RE: FW: Taco Bell, Washington Avenue Portland maine

The following revision was made to the Site Plans dated 7/6/16 to meet the Site Plan Conditions of Approval.

The additional list of revisions to the Site Plans dated 7/6/16, below, were made to clarify the site plans for the Contractor's use during construction.

**Not Approved for Construction**  
 Drawing Title: **Details**  
 Drawing Number: \_\_\_\_\_

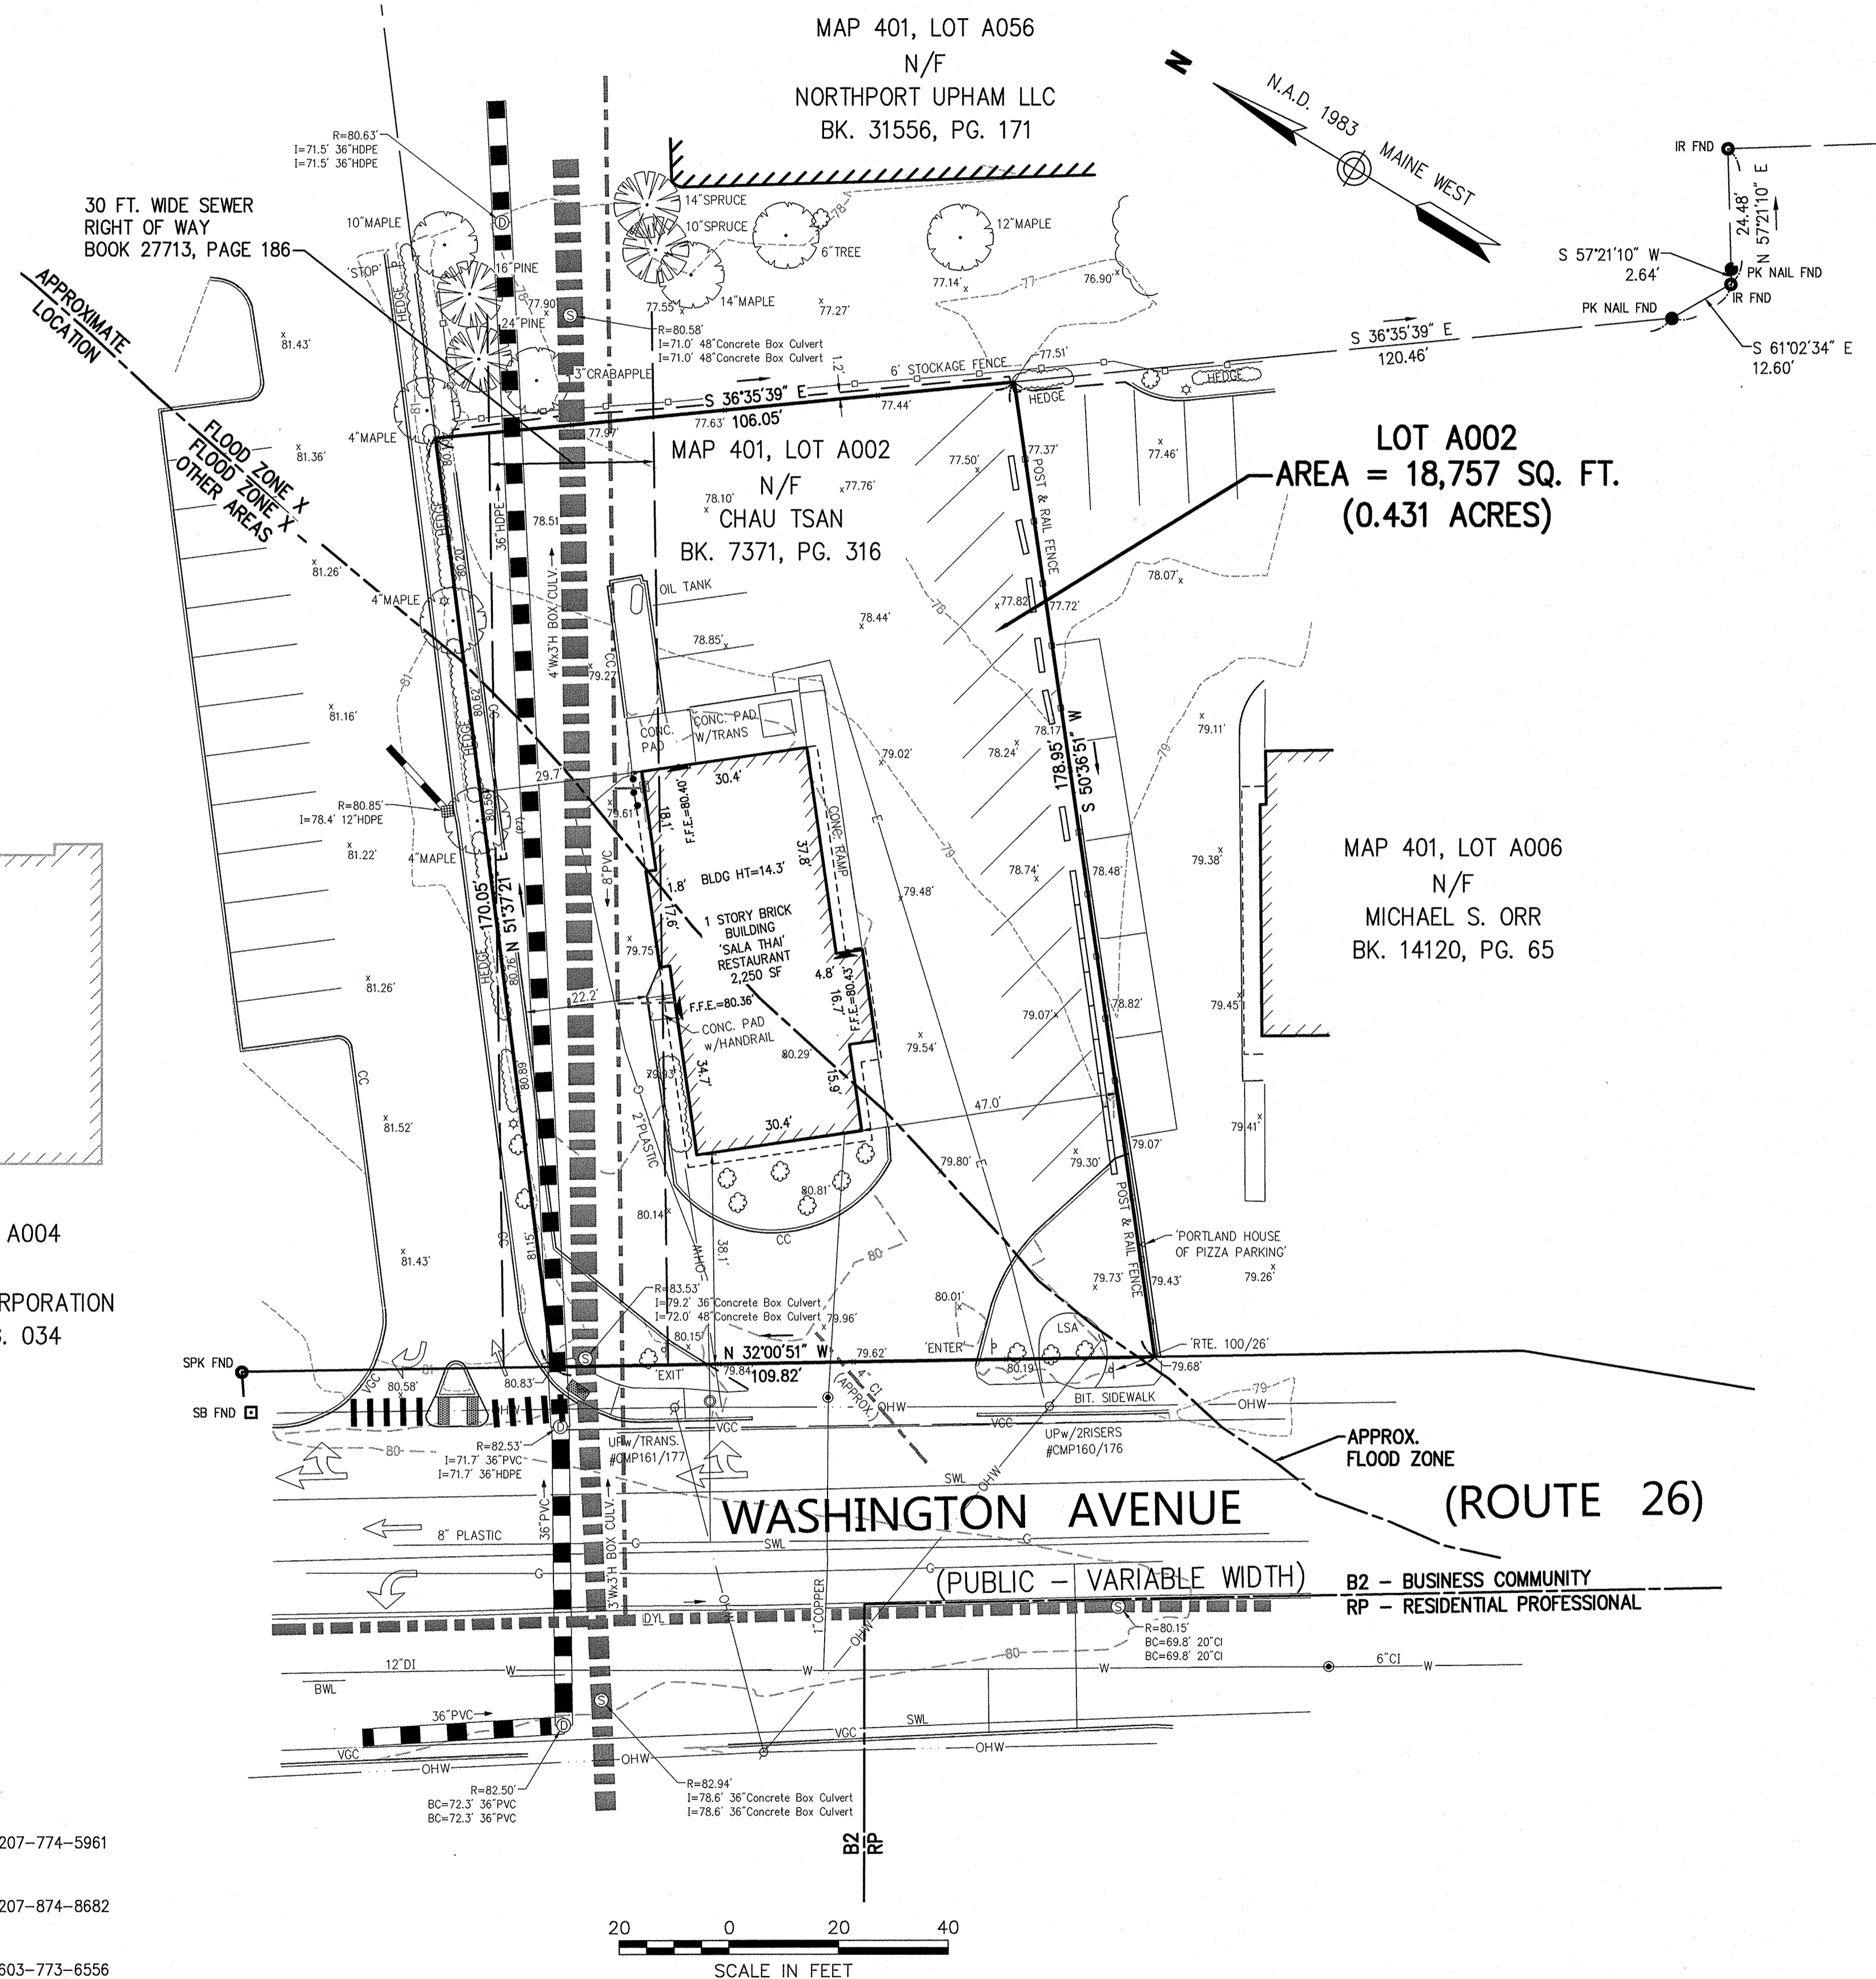
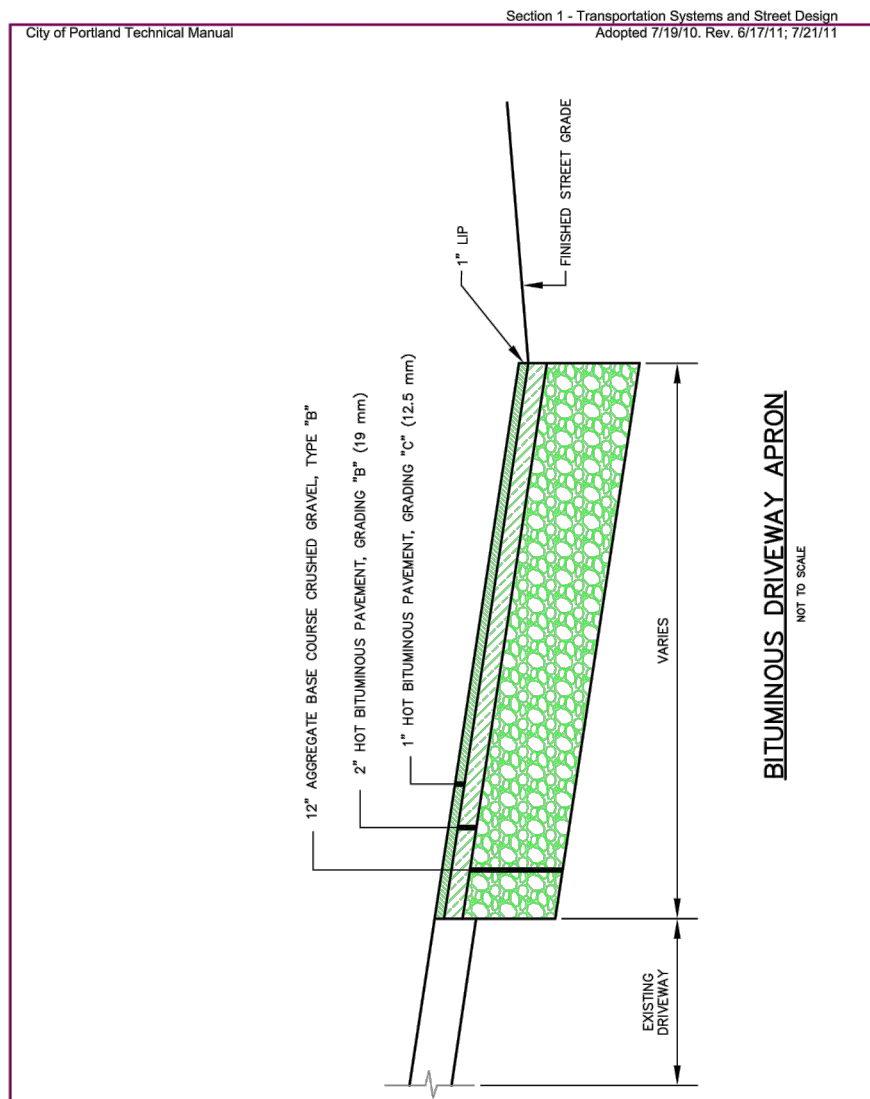
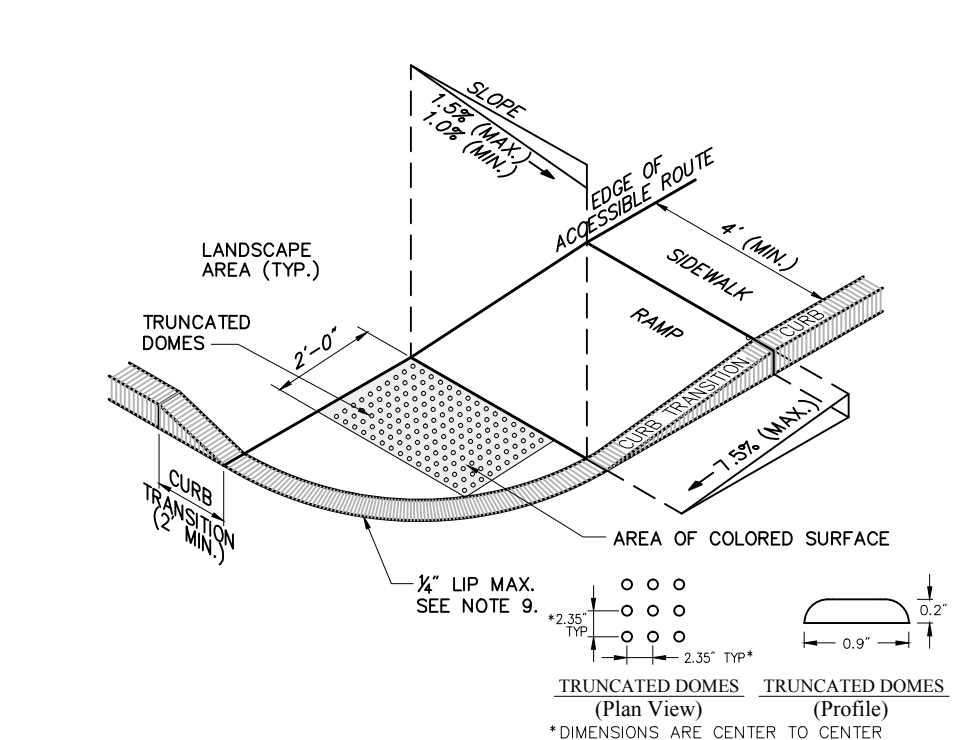
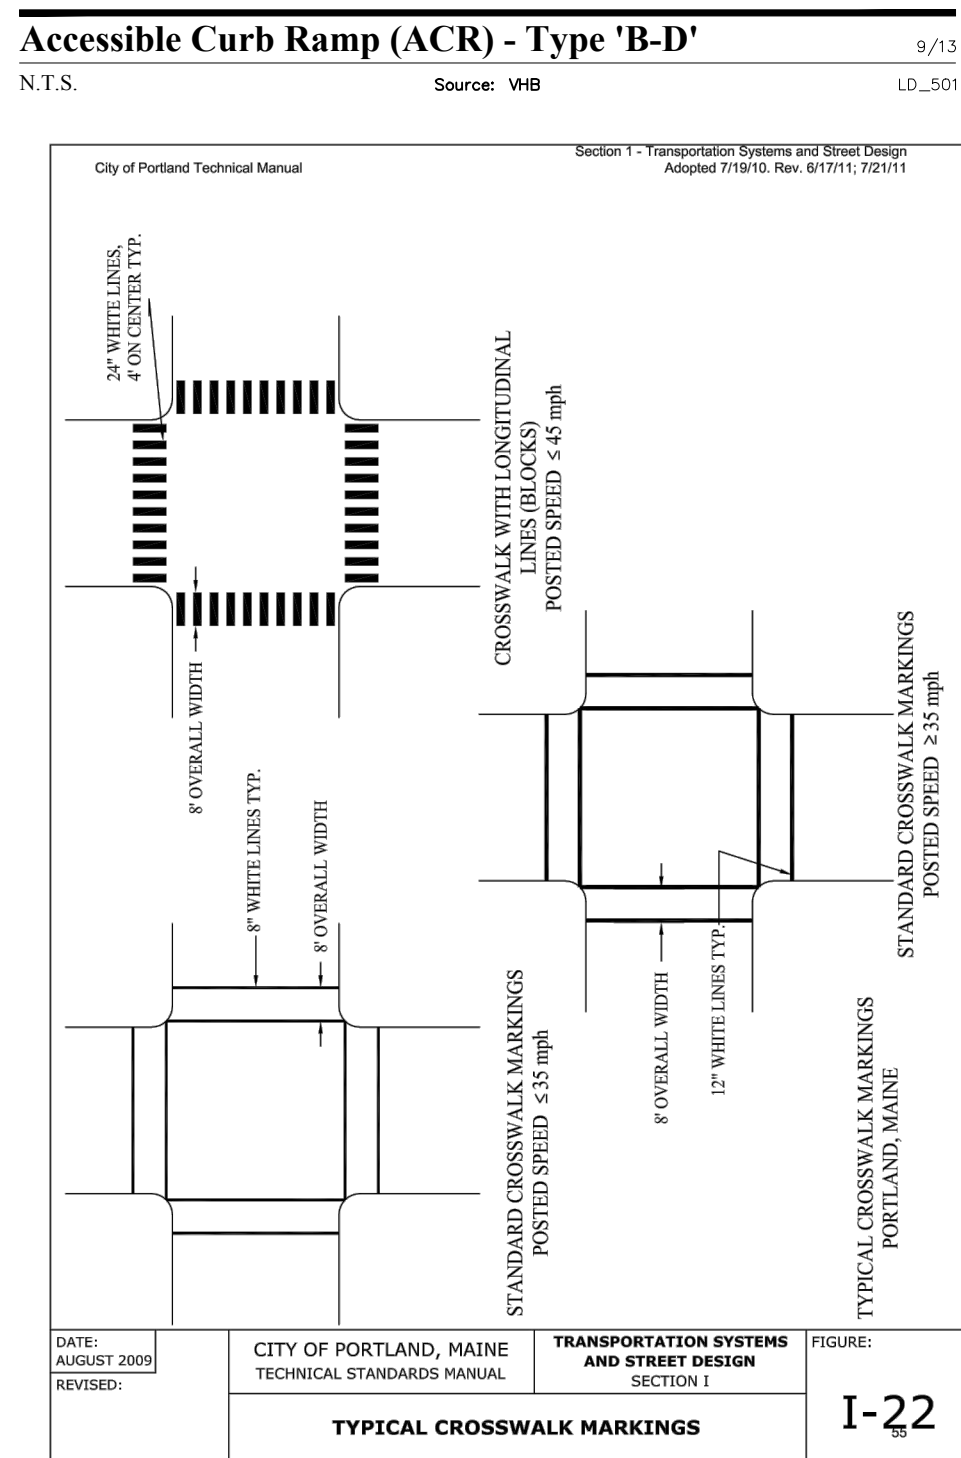
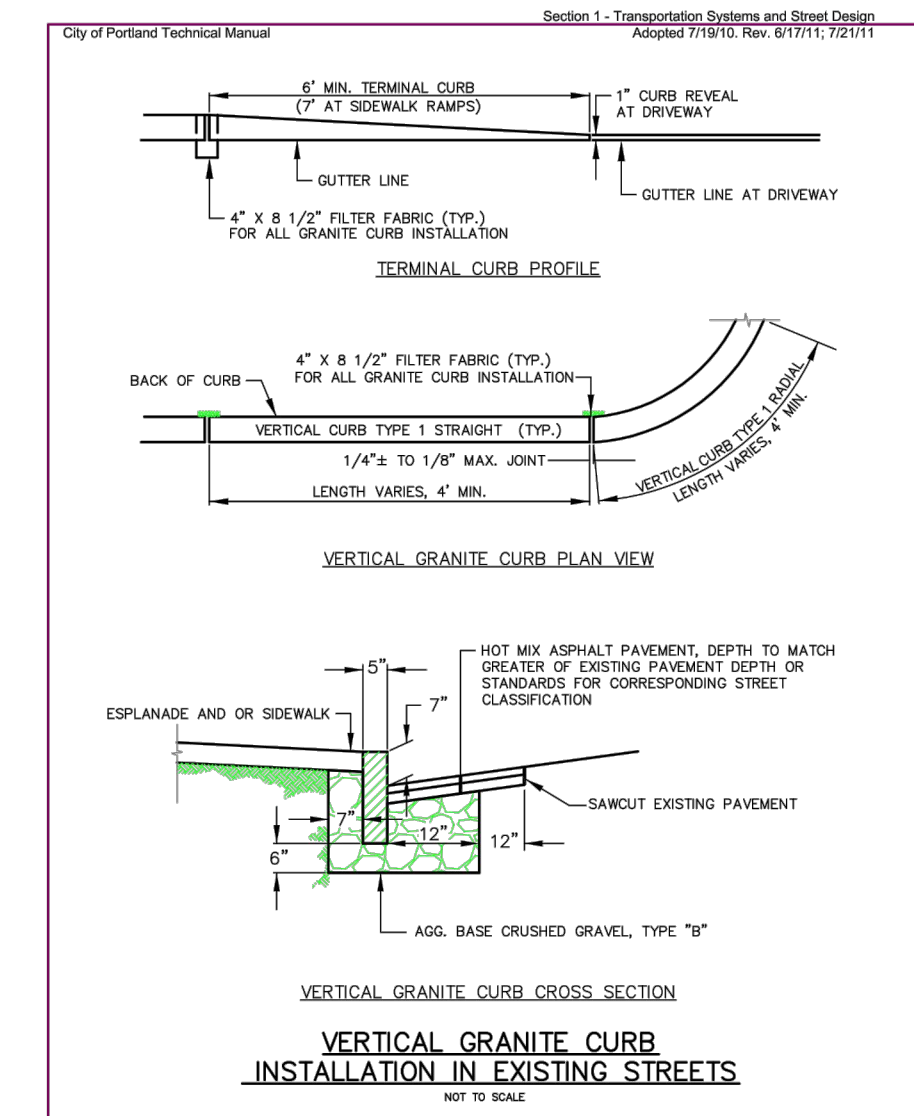
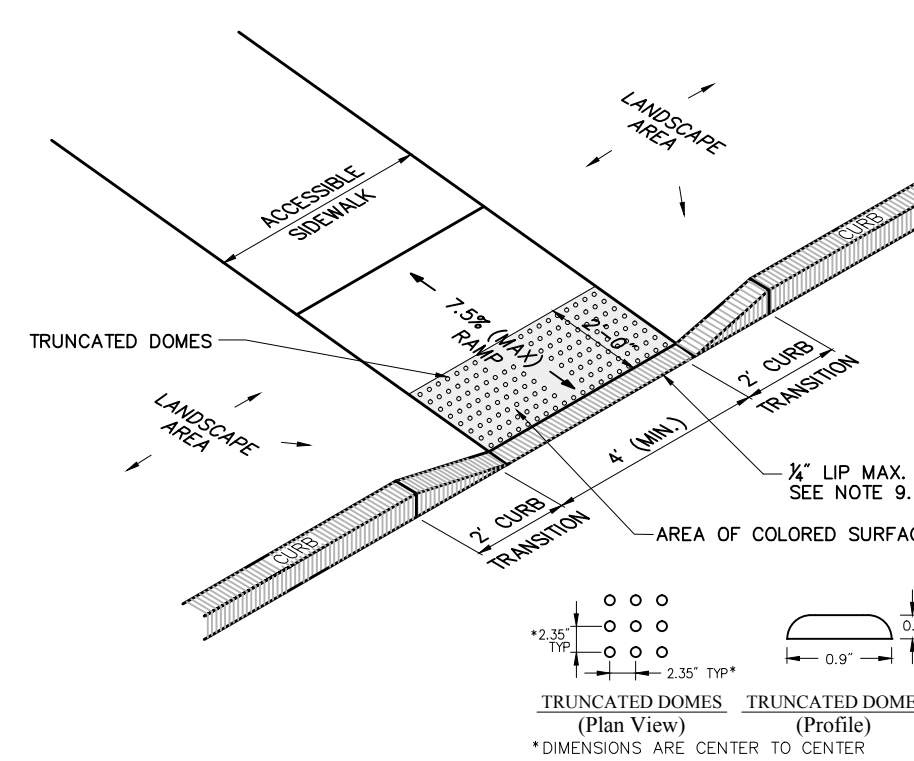
- Details moved to allow similar details to be grouped together
- On-Site Concrete Sidewalk – Added
- Monolithic Concrete Curb and Sidewalk – Added
- Speed Bump – Added
- Rotated Bituminous Driveway Apron Detail and Crosswalk Marking Detail
